SUBMISSIONS REPORT

104-116 Regent Street,
Redfern

15 June 2022

DRAWING TITLE
Level 16 /Level 17 to 18

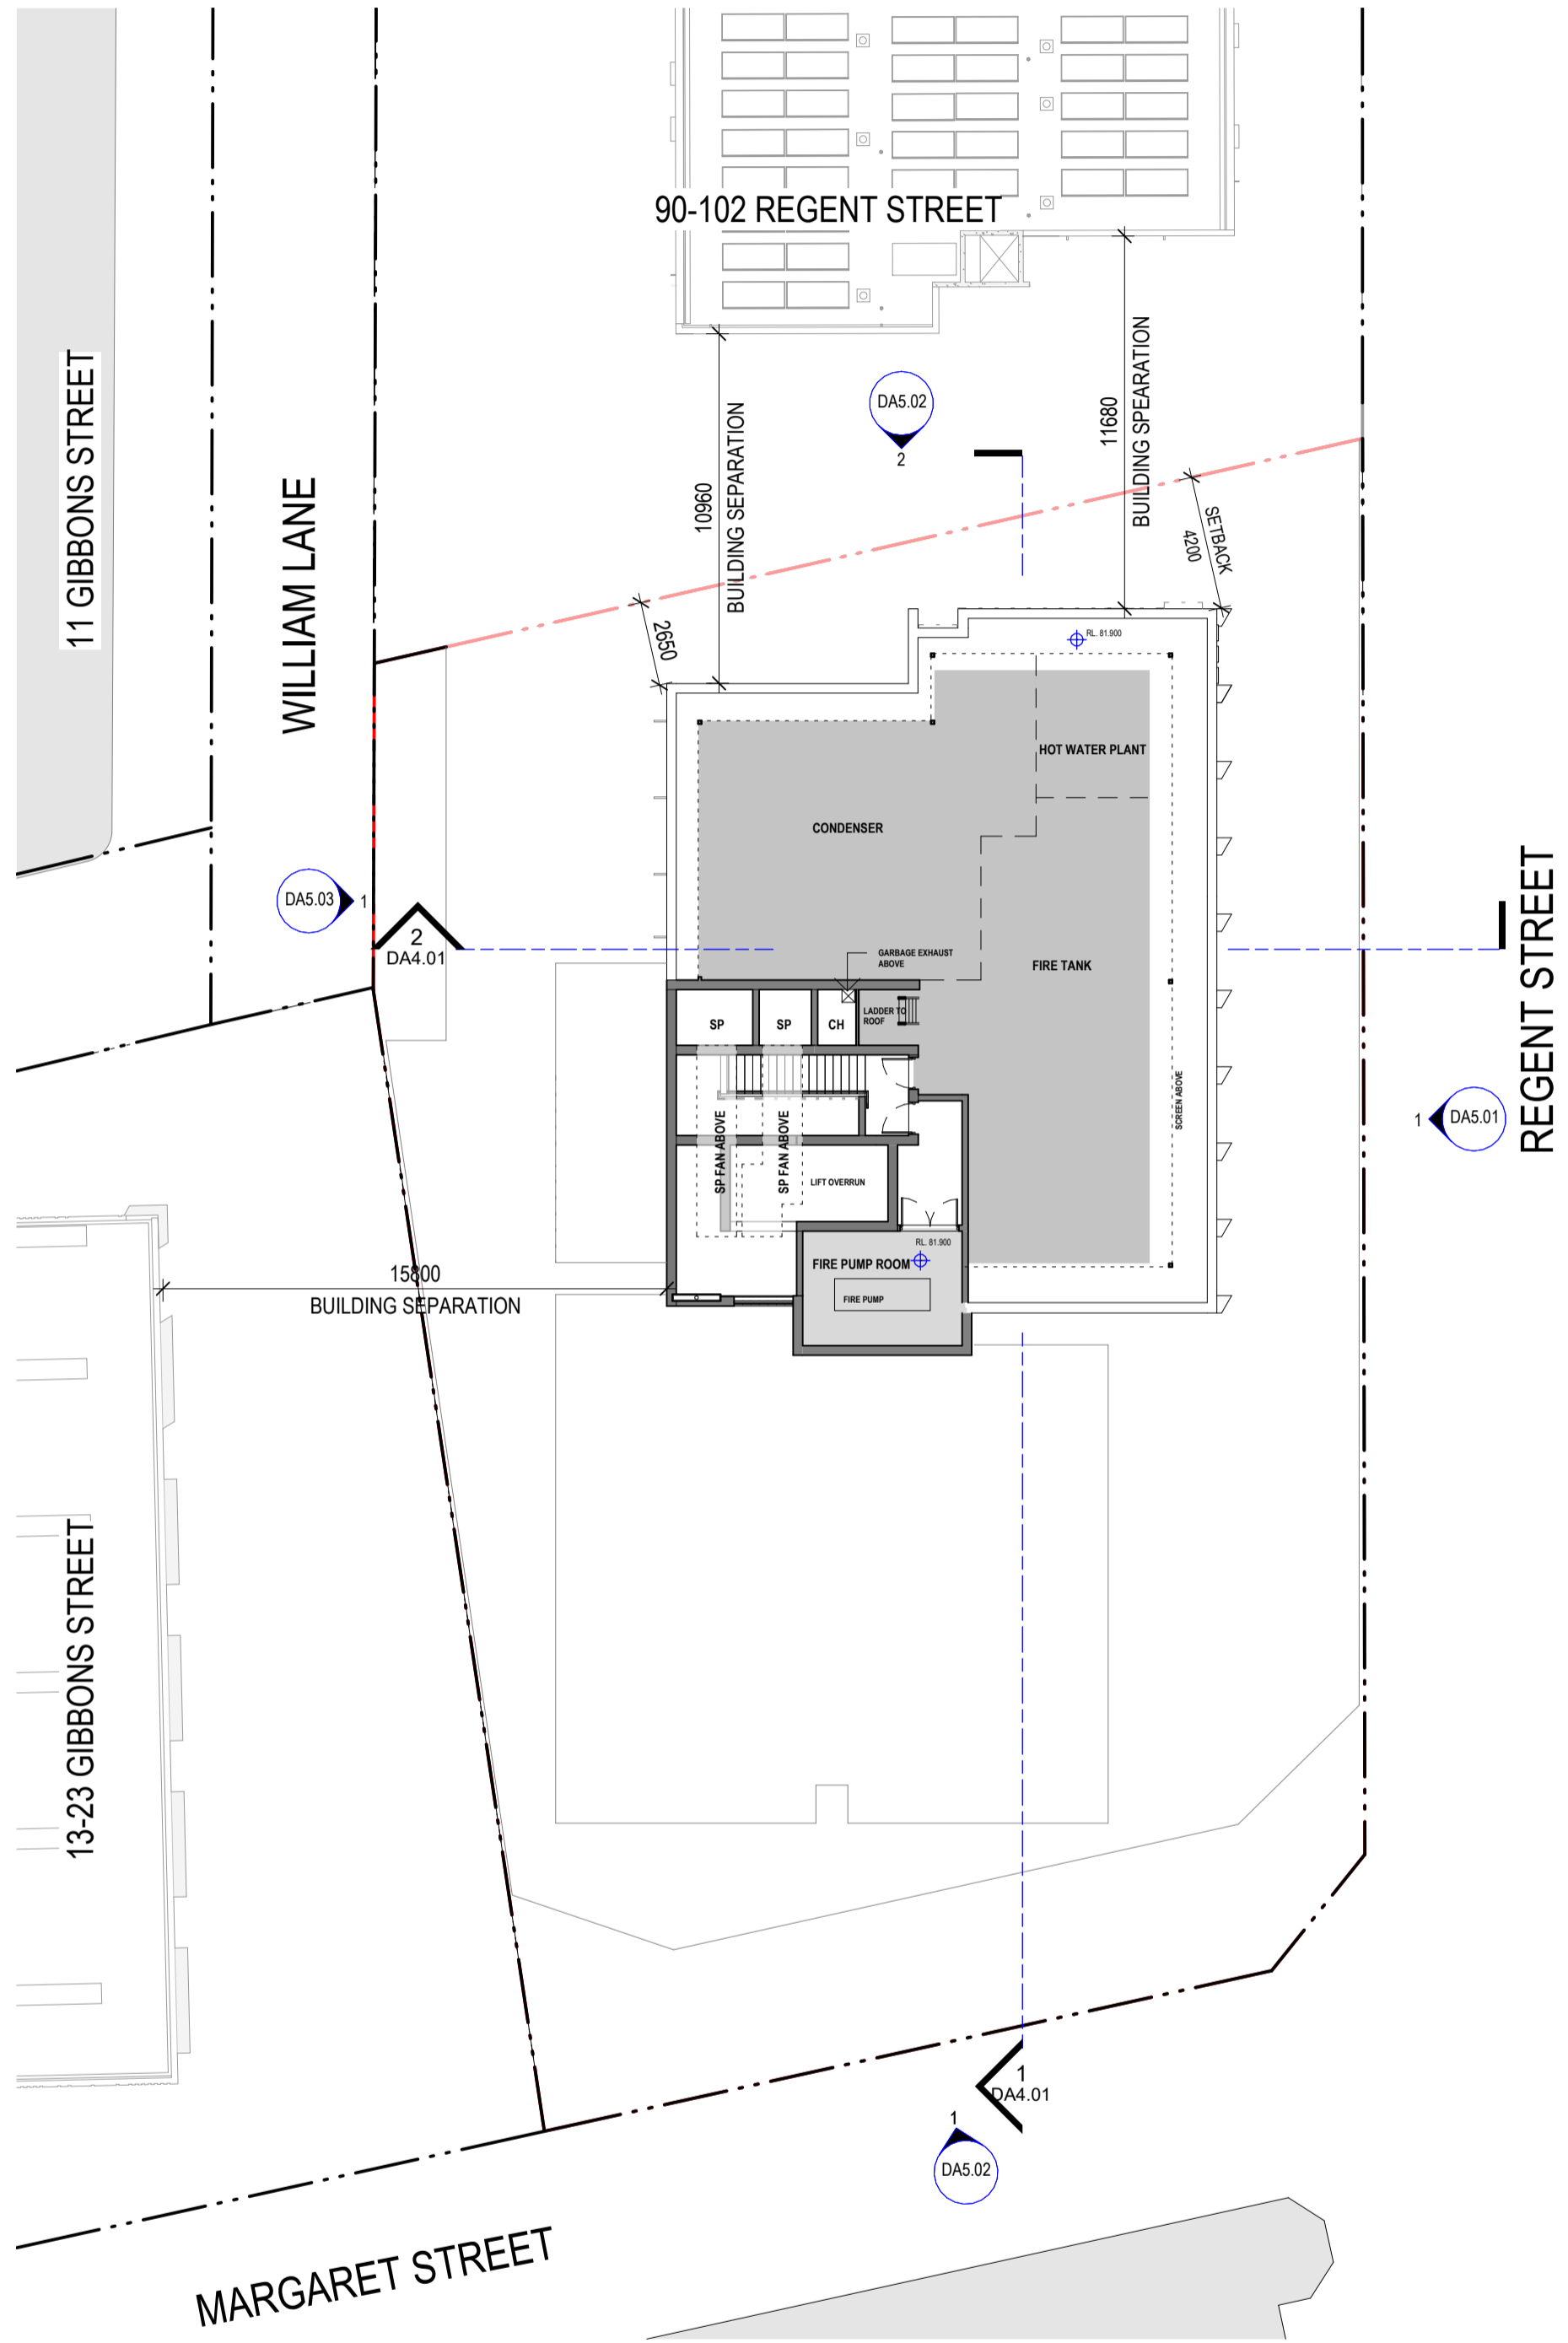
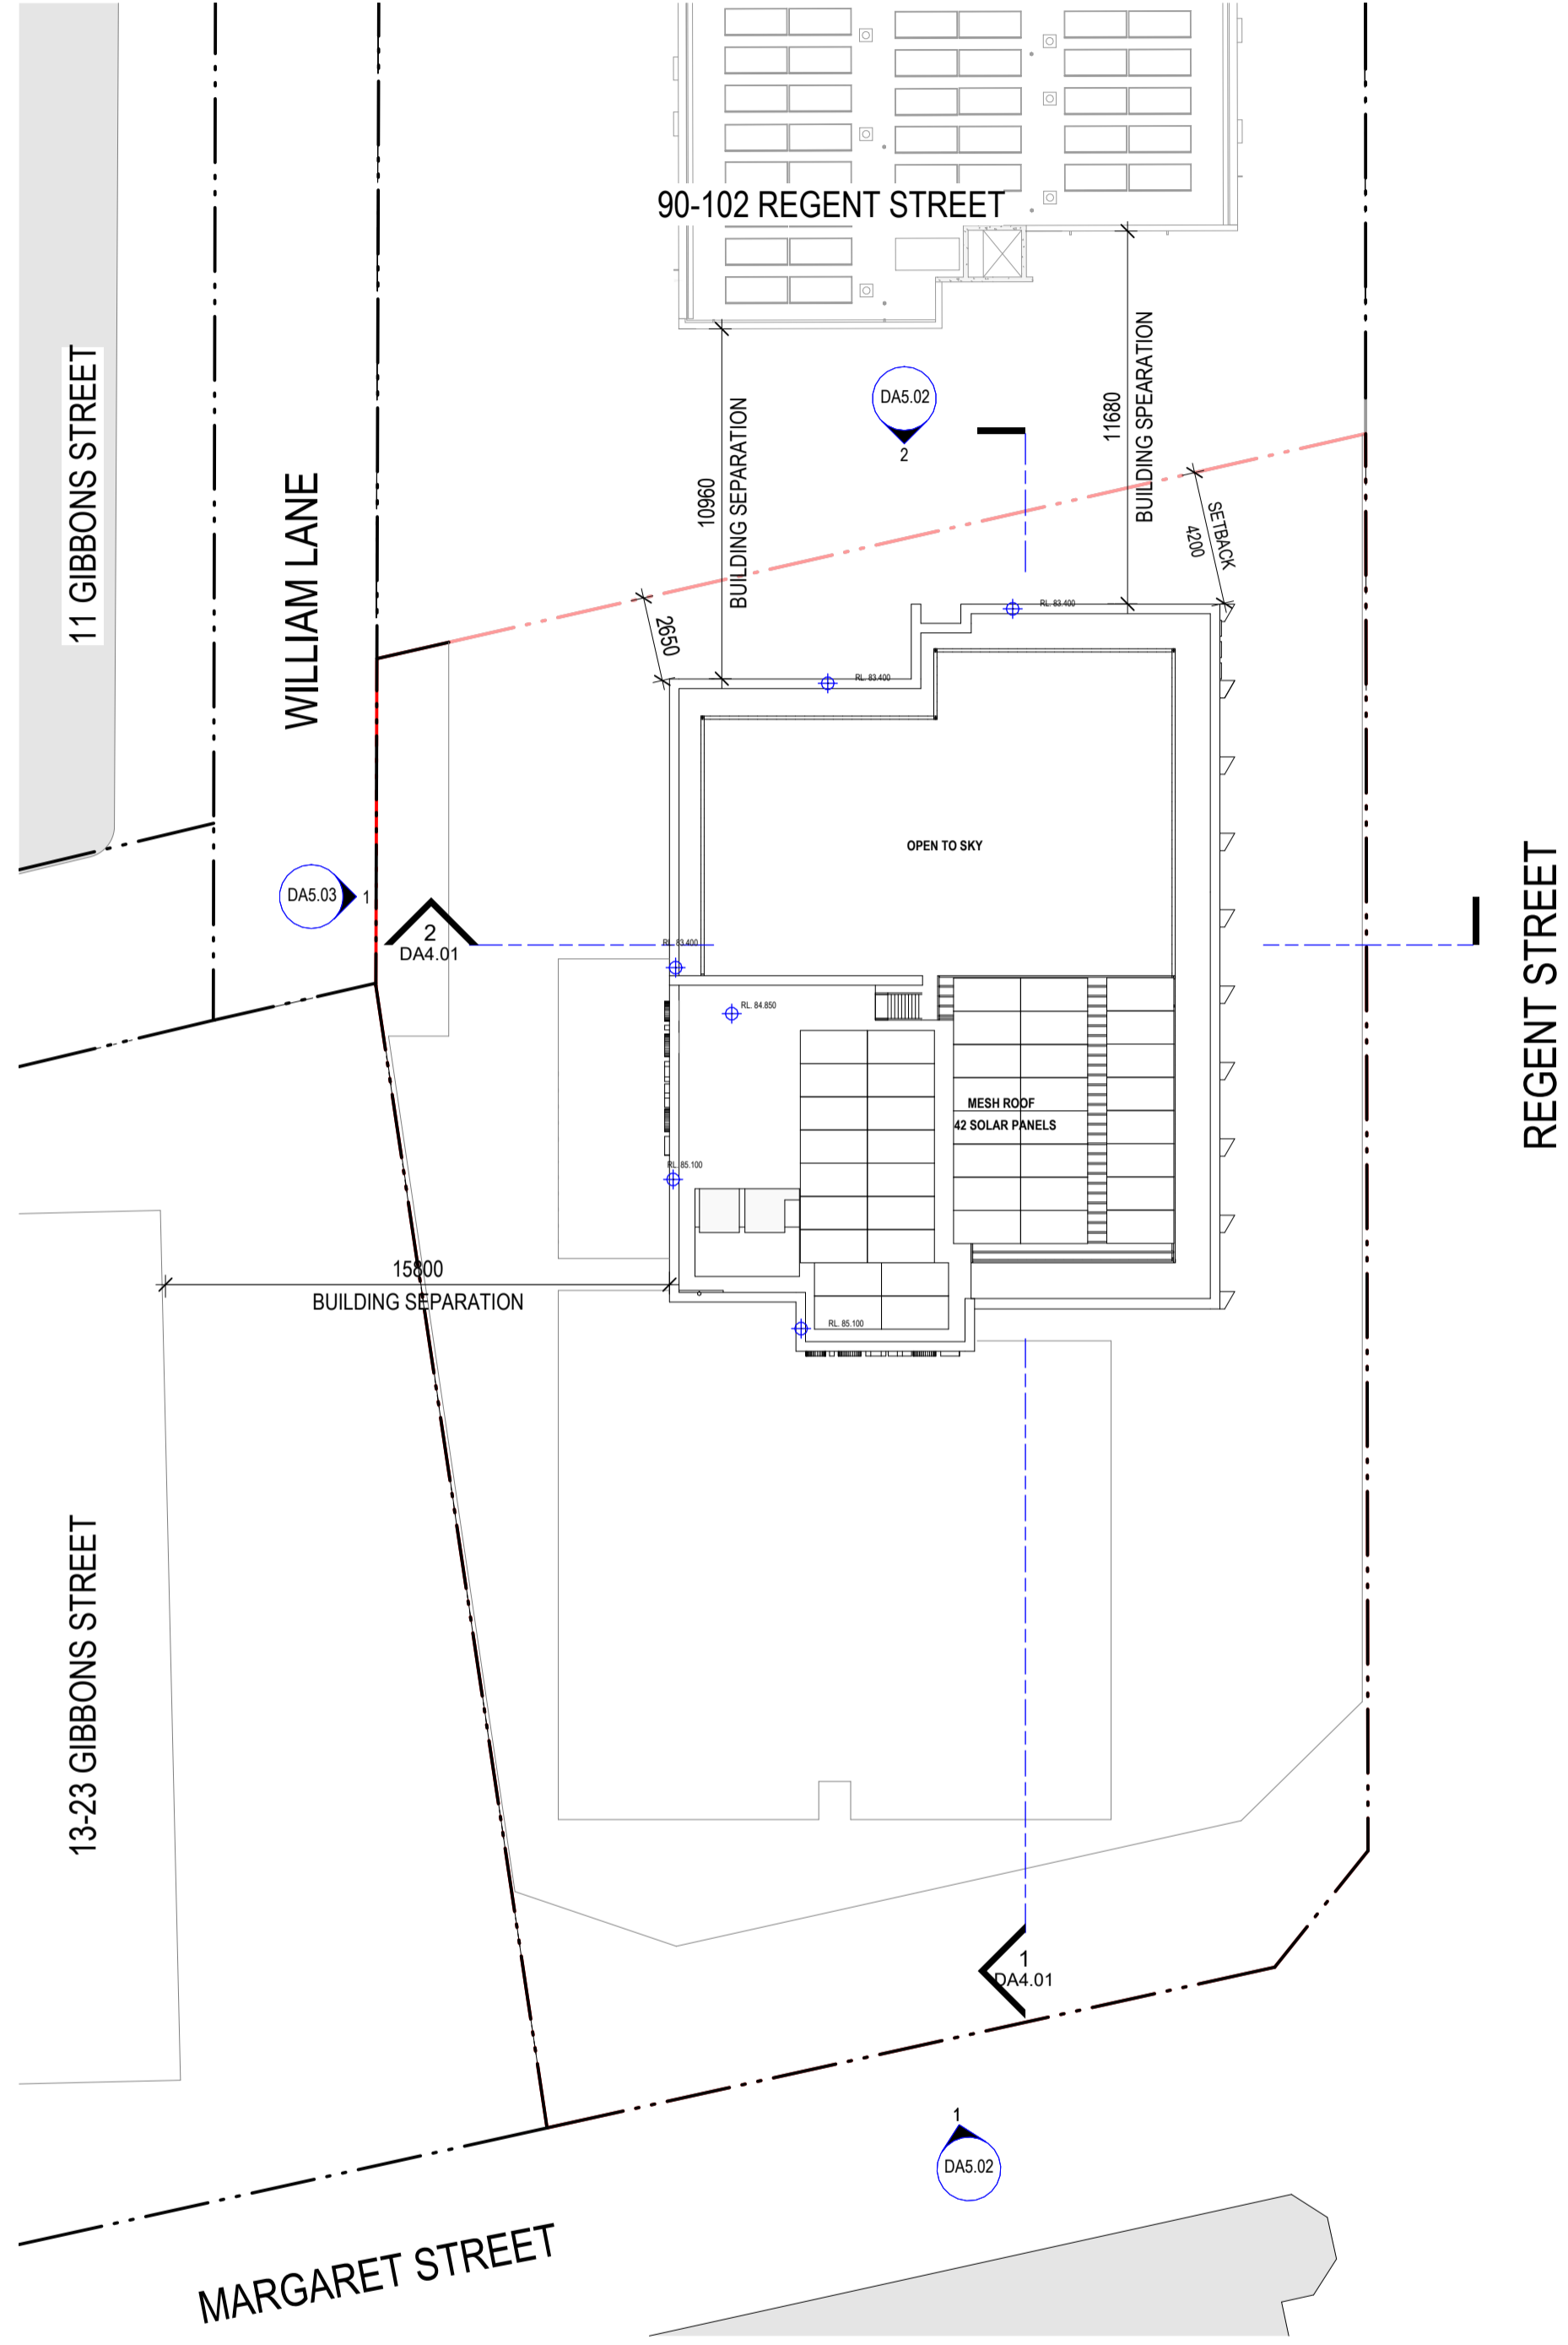
- Further details regarding the proposed design amendments and responses to the DPE feedback (both during and prior to the meeting) are provided in **Section 4.1**. DPE raised concerns about the overall height of the building being read as a 19-storey building due the plant and lift overrun. The Department recommended minimising the plant so the building does not read as a 19-storey building.

- Council's waste officer recommended the separation of the retail and residential bins and the provision of bulky waste for the retail uses.
- Council raised concerns about the overall height of the building being read as a 19-storey building due the plant and lift overrun.

- **Reduction in building height:** Significant changes have been made to the siting and design of the rooftop plant and equipment to minimise potential visual impact and avoid the perception of this forming an additional storey. The rooftop plant has been setback from the perimeter and the parapet height reduced from 3.55m to 1.5m. Metal louvre screens have been included around the equipment to conceal the visible portion of the plant equipment behind.
